Application by BSSL Cambsbed 1 Limited for an order granting development consent for the East Park Energy project (EN010141)

East Park Energy

Summary of Cambridgeshire County Council Relevant Representations PINS Project Reference: EN010141

FIGURE 3 – INDICATIVE DRAINAGE LAYOUT

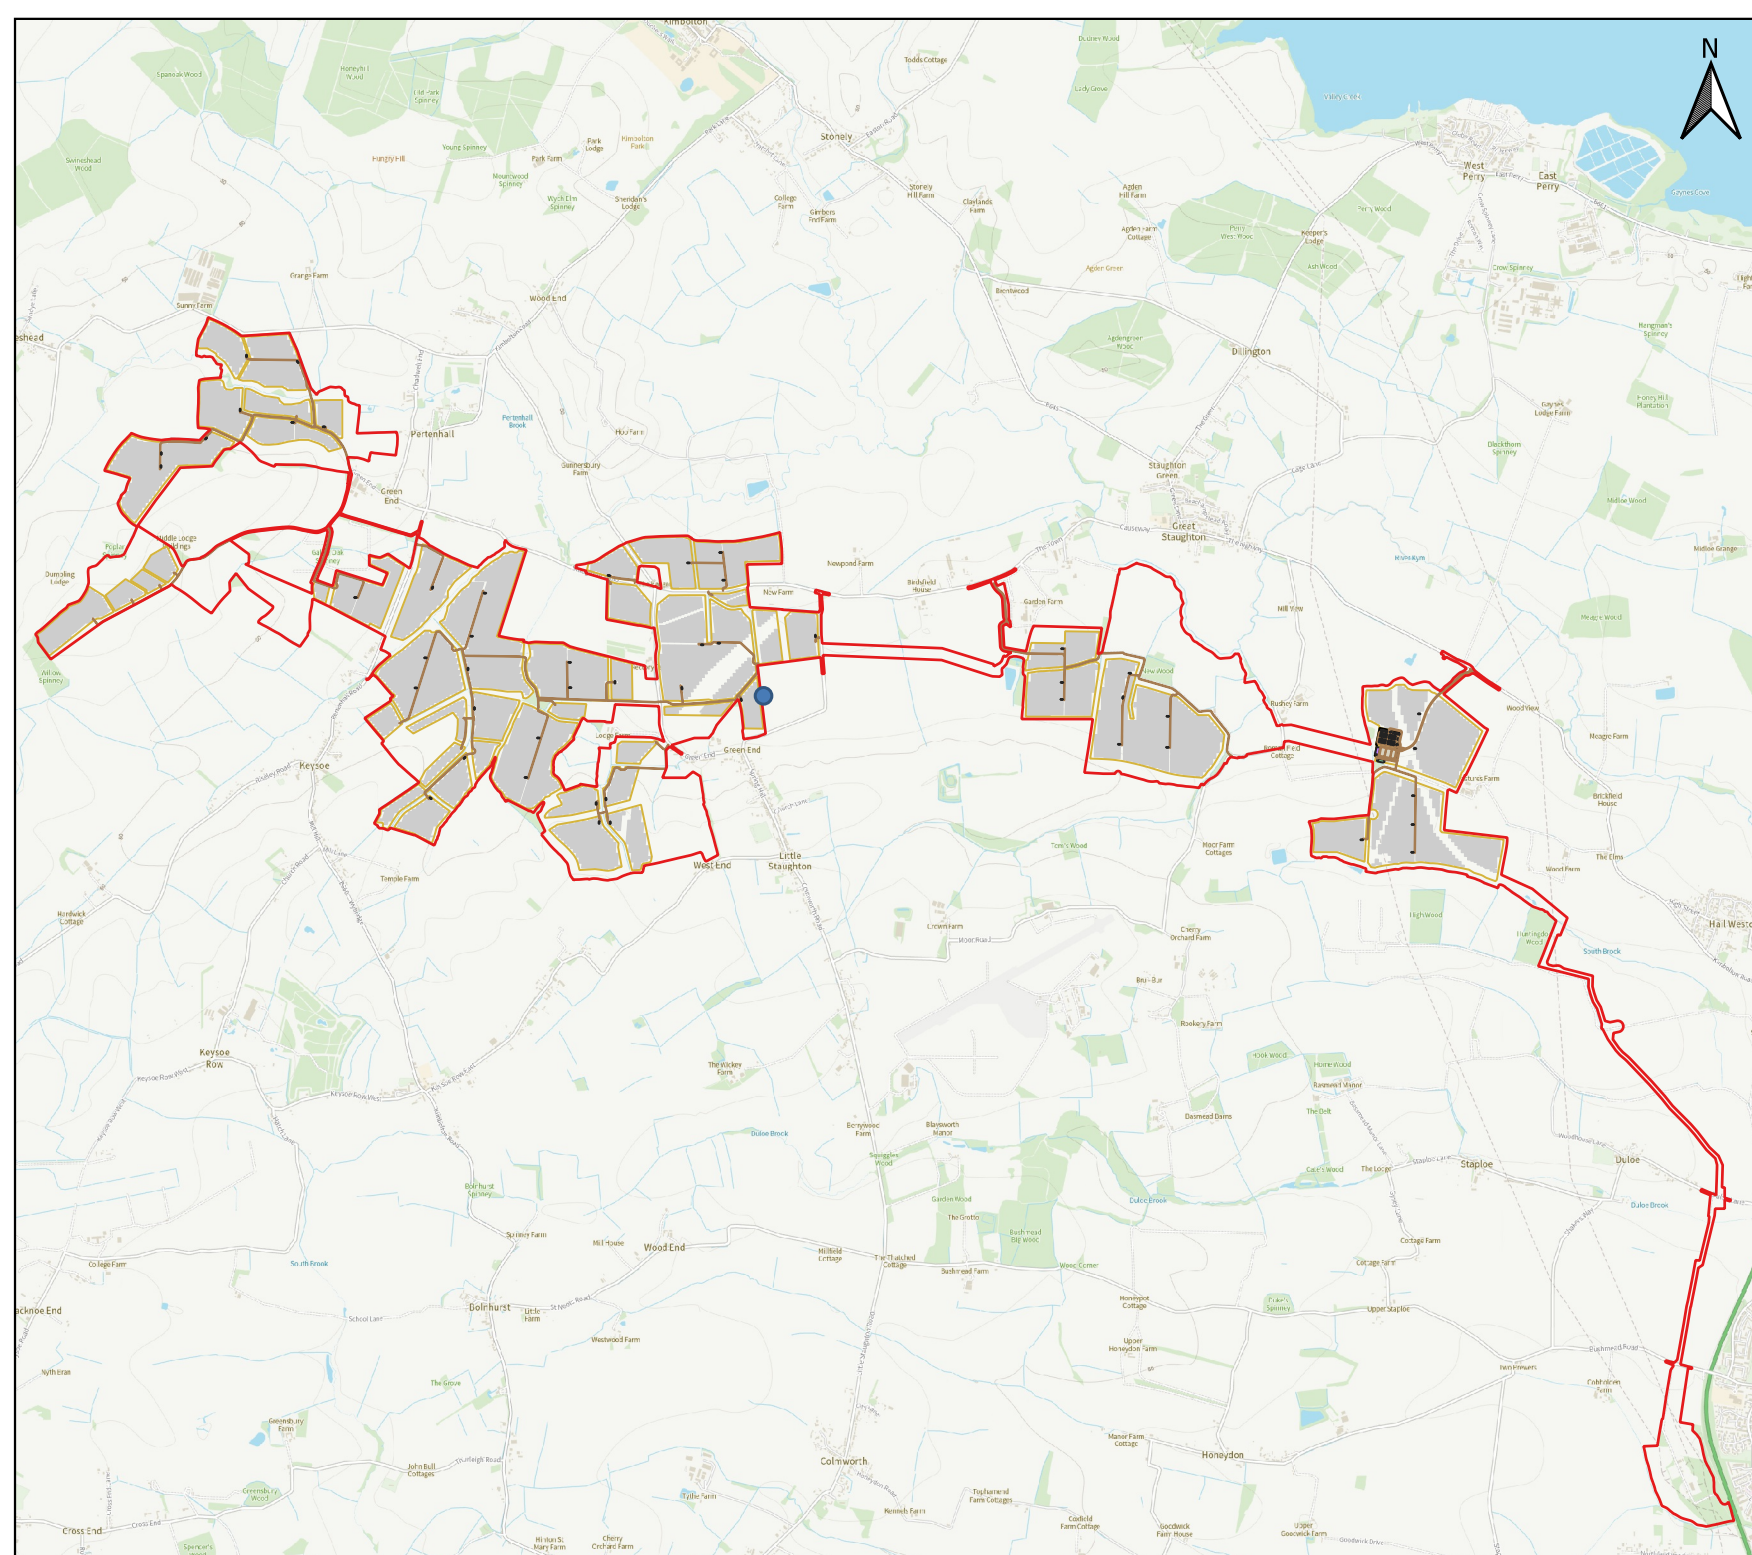
- Drainage layout plans for each catchment.
 - Demonstration of pollution risk areas and how water is managed during all stages for each catchment.
 - Flow rates for each individual catchment
